**Addendum:
response to
Hillingdon and
GLA comments**

Urban Design Comments, Addendum UD6B: Proposed parking strategy for Courtyard

Proposed Ground floor plan showing wheelchair / ambulant disabled user access to the external platform lift

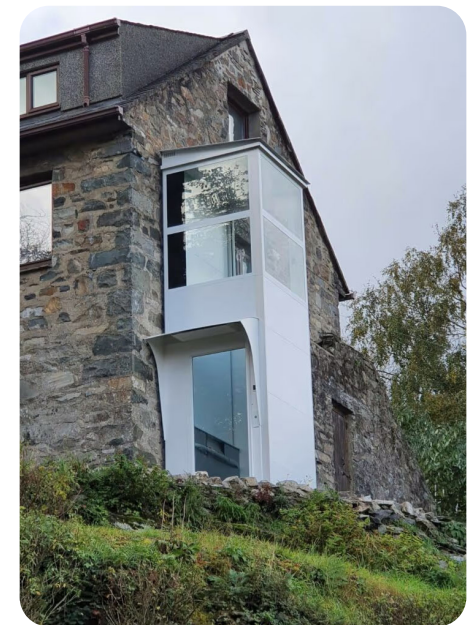
A external platform lift will provided to allow level access from the front podium to the internal courtyard garden.

We propose an external lift for wheelchair and ambulant disabled users that connects the Ground level podium to the lower ground floor and rear courtyard.

Wheelchair and ambulant disabled users can call the lift at the ground floor podium and travel to the lower ground floor and access the rear courtyard via the car park. Similarly the lift can be taken from the lower ground floor (where the car park is located) up to the podium level.

The lift shall be Approved Document Part M (ADM) compliant a minimum plan area of 1100mm by 1400mm. All the controls shall be compliant with ADM.

Axo view to the East / West facade showing the proposed planter

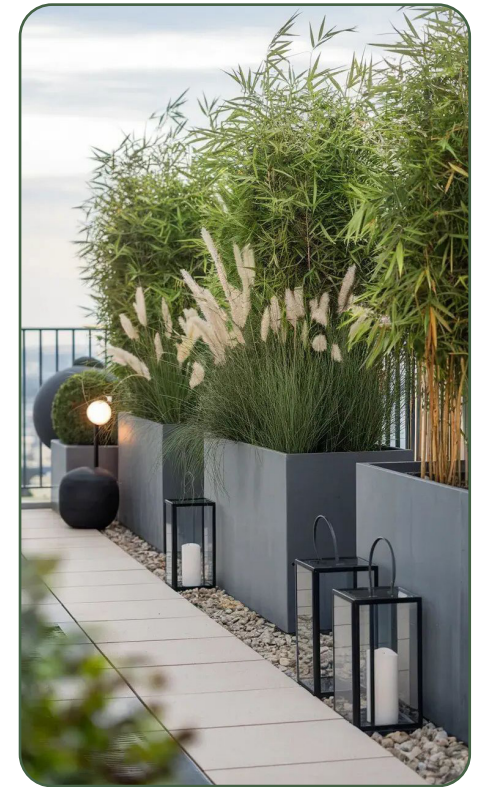
Urban Design Comments, Addendum, UD6H: Balcony Privacy Screen

To provide a robust privacy screening we propose a solid planter that can be shared with a neighbour. To the East and West elevations, the planter is 1.1m high to tie in with the balustrade datum. In addition a shared trellis is shown at the back of the planter. The trellis is made from metal wires that span from the planter to the soffit. It allows the residents to grow their own climbing plants, that be nurtured individually or between neighbours. The density of the trellis can be increased in dialogue with your neighbour.

A solid privacy screen would detract from the overall design that is focused on community and openness.

Plan and Axo view to the South Elevation showing the proposed planter

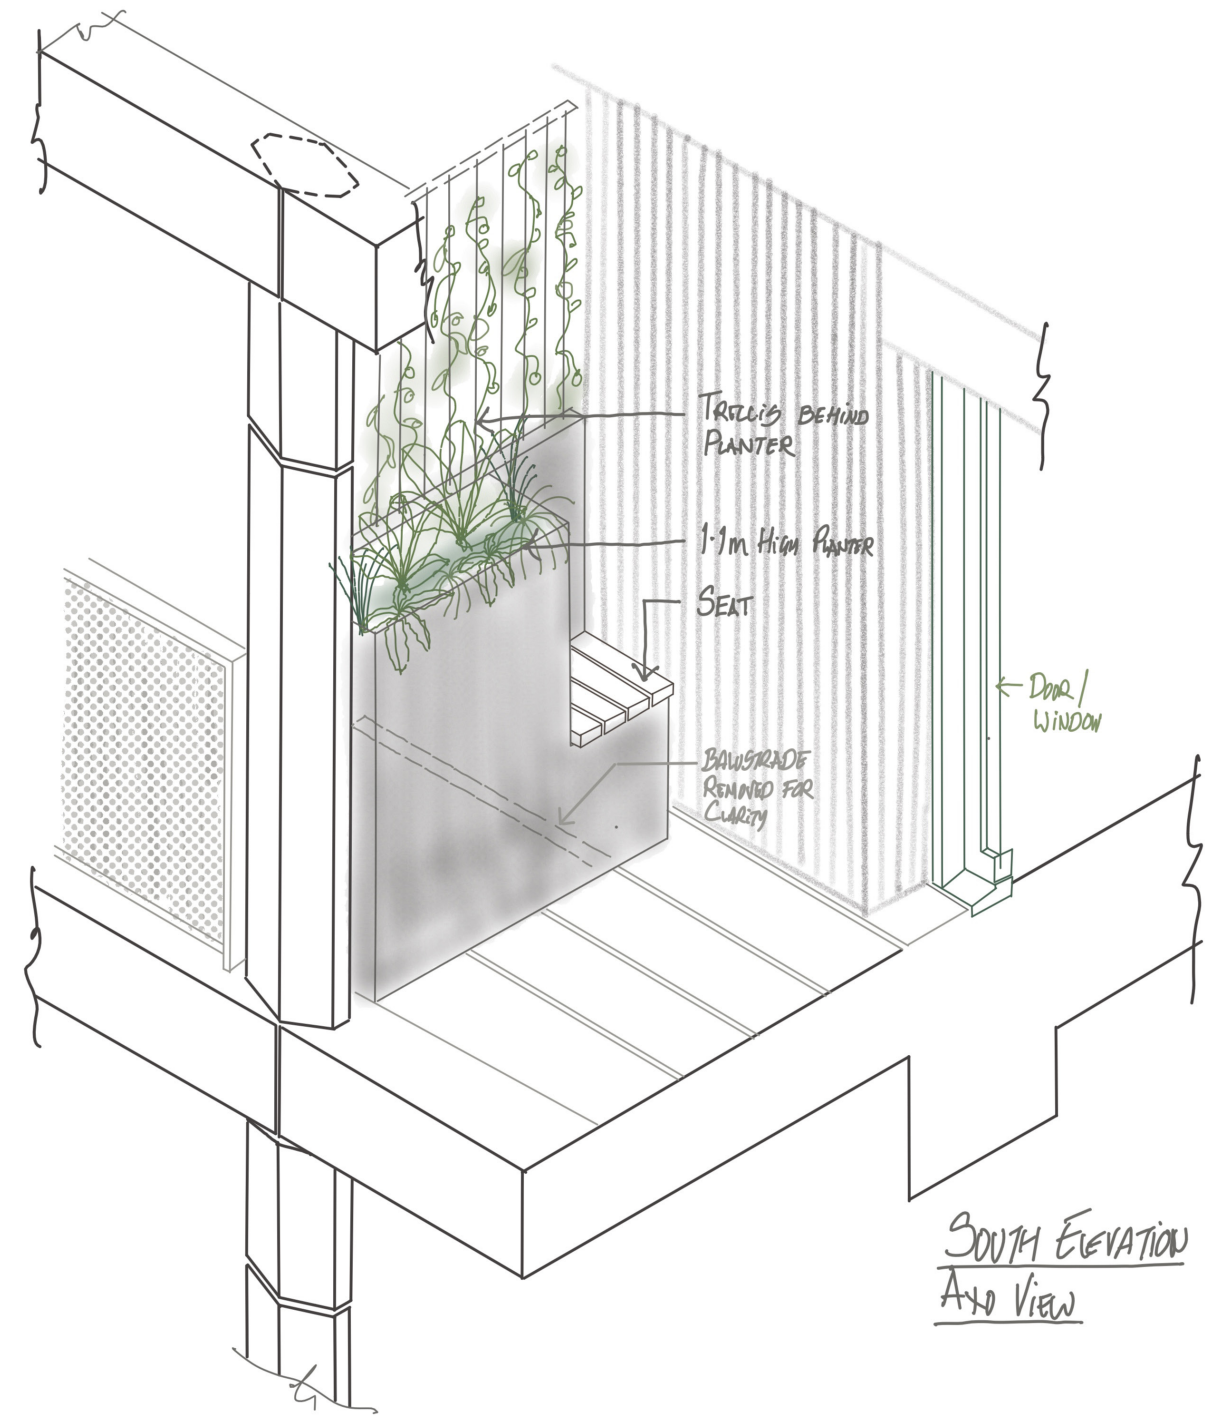
Urban Design Comments, Addendum, UD6G: Balcony Privacy Screen

To the south elevation, the 1.1m high planter is lengthened and includes a bench. The wider planter gives more options to explore new planting. A bench nearby the elevation provides an opportunity to rest and enjoy the wider terrace. The planter is maintained by the resident on the lower side, next to their seat. Using this arrangement there will be at least one planter for each flat.

A metal trellis with vertical wires is located at the back of the planter and seat to provide a robust but transparent screening. A shared trellis is shown that can be grown individually or between neighbours. The density of the trellis can be increased in dialogue with your neighbour.

Diagram showing the proposed vehicular access around the Site

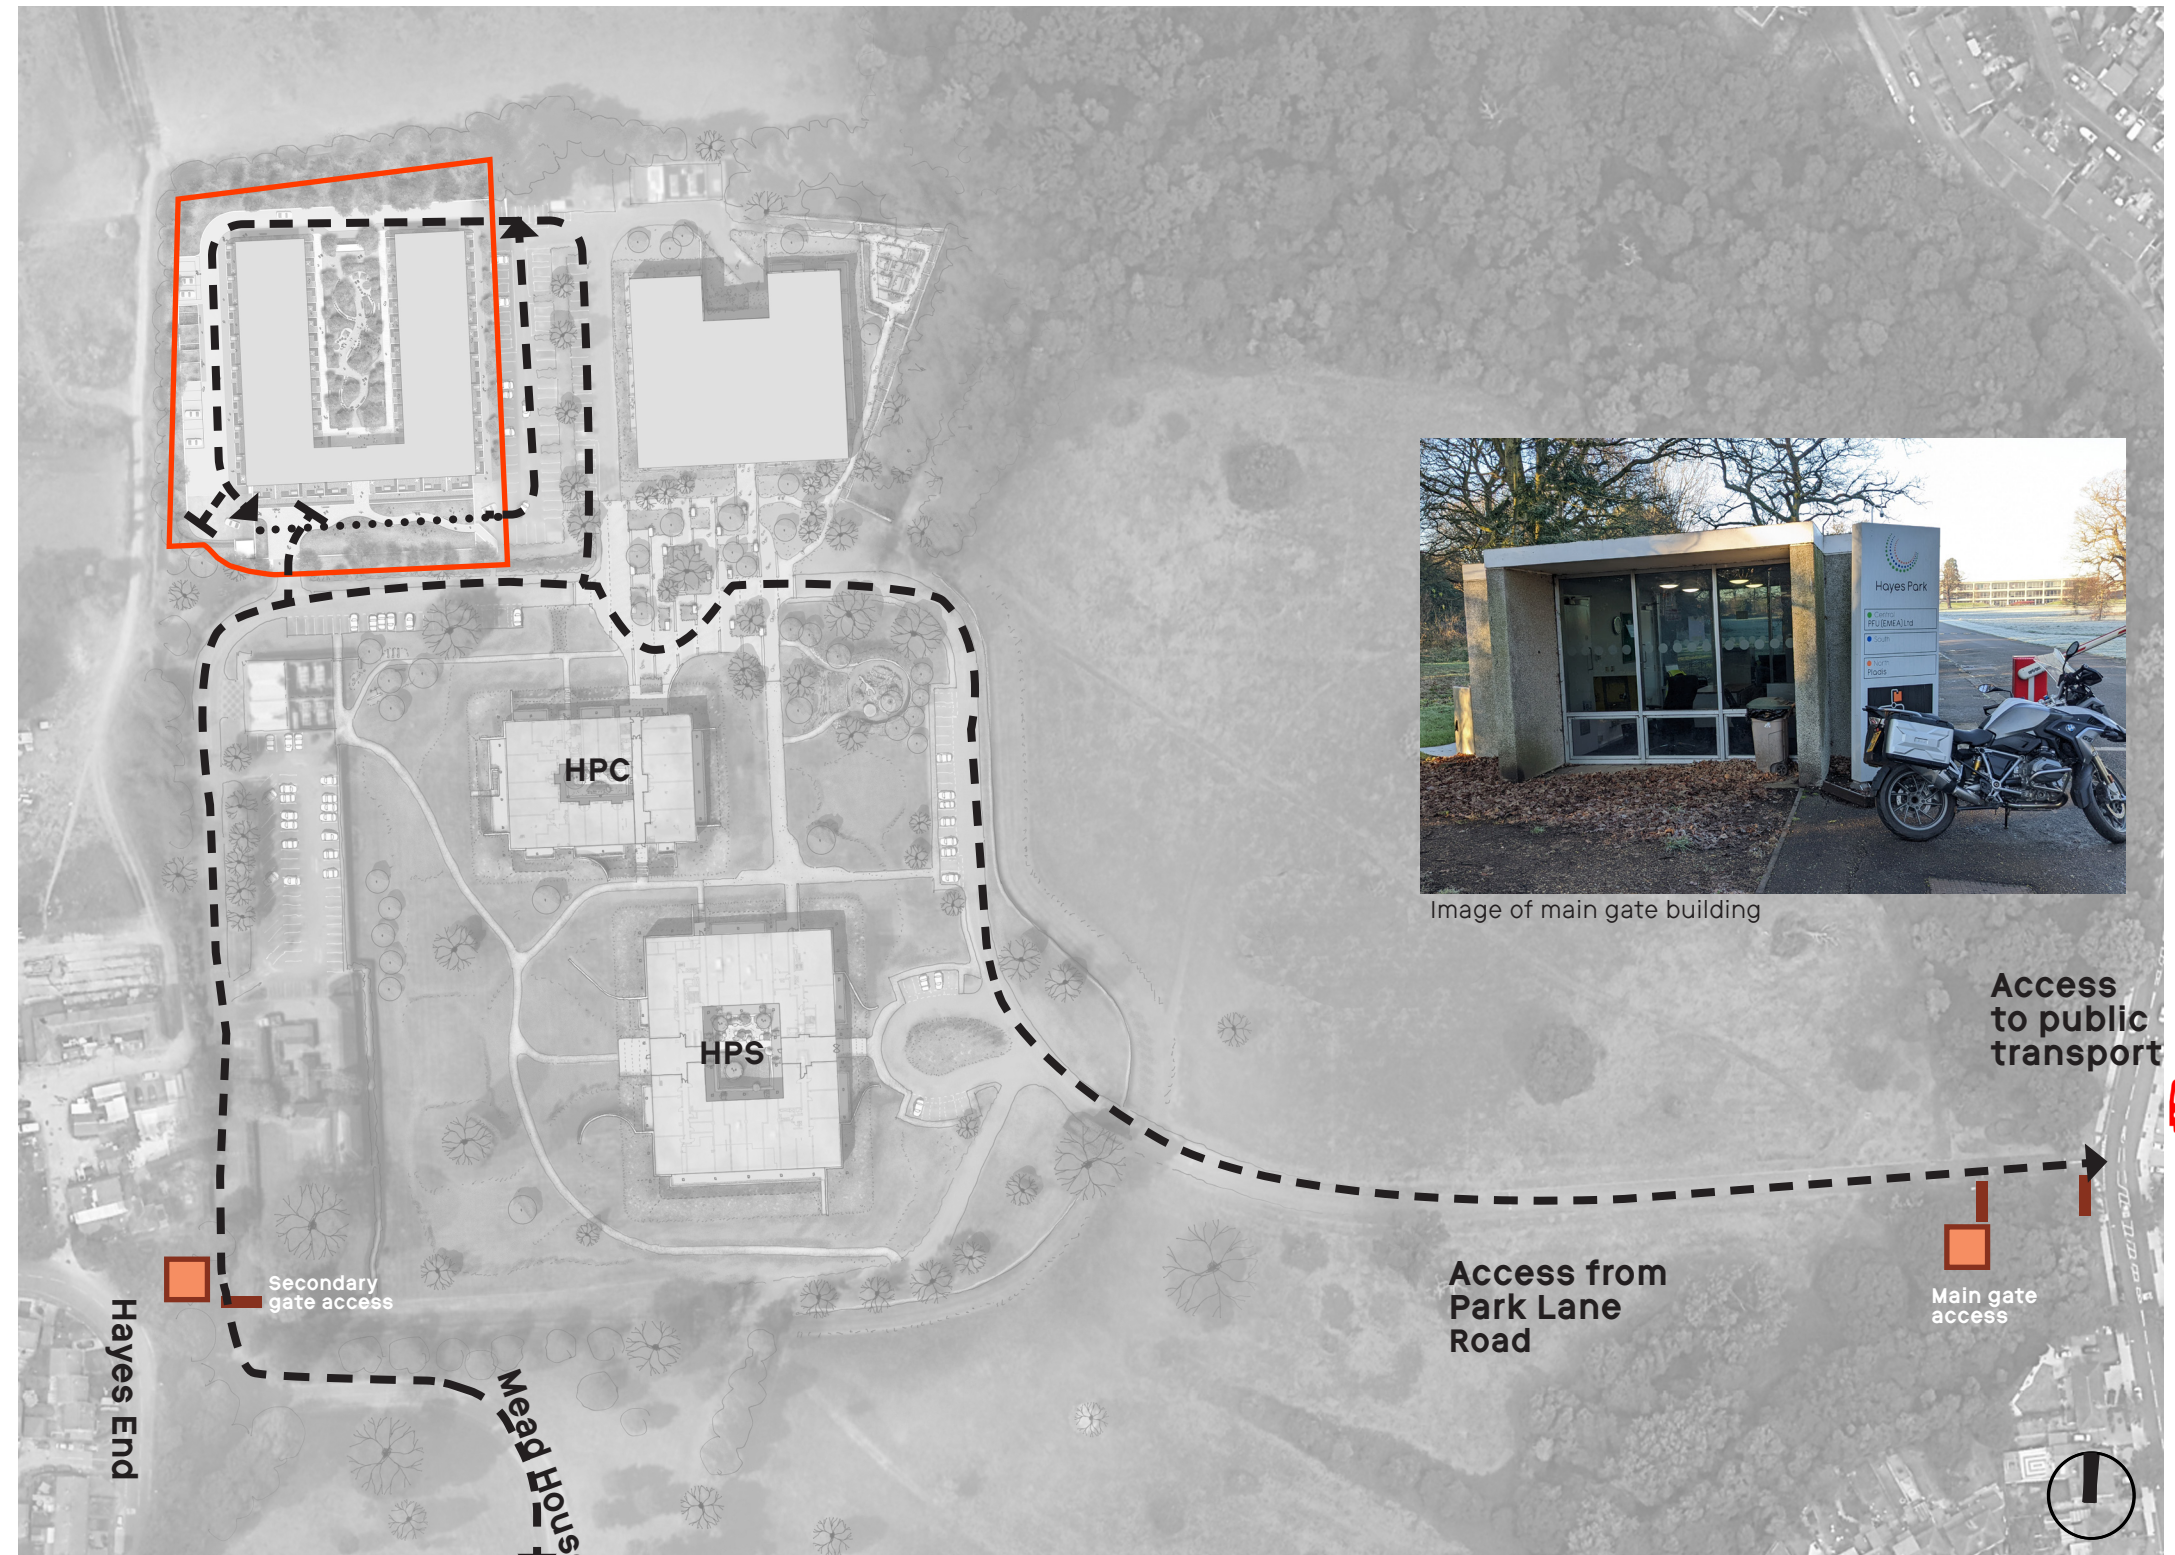
Urban Design Comments, Addendum, UD6K: Proposed vehicular main access strategy with managed delivery

The proposed access strategy looks to reuse the existing access points and estate road.

The buildings and parking on Site will be accessed via the existing estate loop road. This is either entered from Park Lane to the east, or Hayes End Road to the west. Both routes connect to Uxbridge Road, which runs to the south.

Each vehicular entry point will be gated, with residents only access controlled by fobs.

There is an opportunity to reuse the existing main gate entrance building as a concierge. This will form part of a wider management strategy for the whole estate. Deliveries to the site will be dropped off at the Main Gate Buildings on Park Lane Road, and Hayes End Road. These Buildings will be occupied during standard working hours.

Lower ground floor showing routes to cycle stores and visitor stands in the landscape

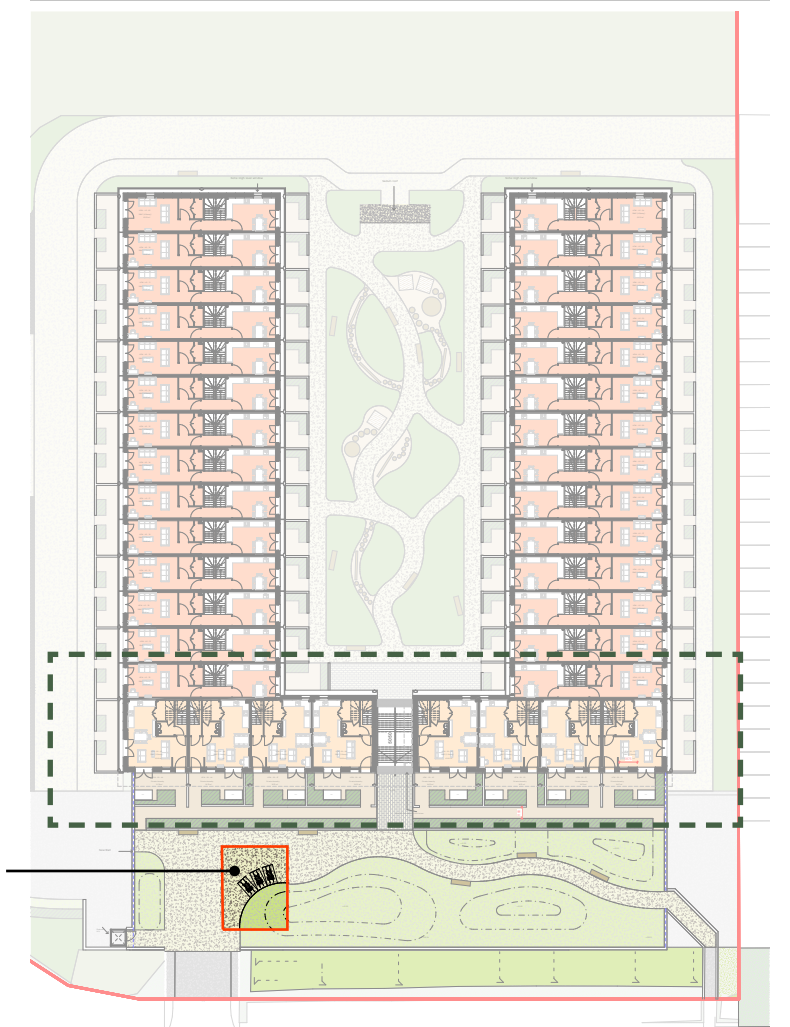
GLA Comments item 43, Addendum: Cycle Provision reviewed

The central cycle store is proposed within the lowered ground floor adjacent to the carpark.

The cycle store to HPW is accessed via the central courtyard externally or via the car park. In addition there is an external exit /access door to the eastern facade. The centralised store will be bright and welcoming.

A bike ramp will also be provided on one side of the central stair leading down from the podium level.

The short stay spaces are located with the landscape as shown on the plans.
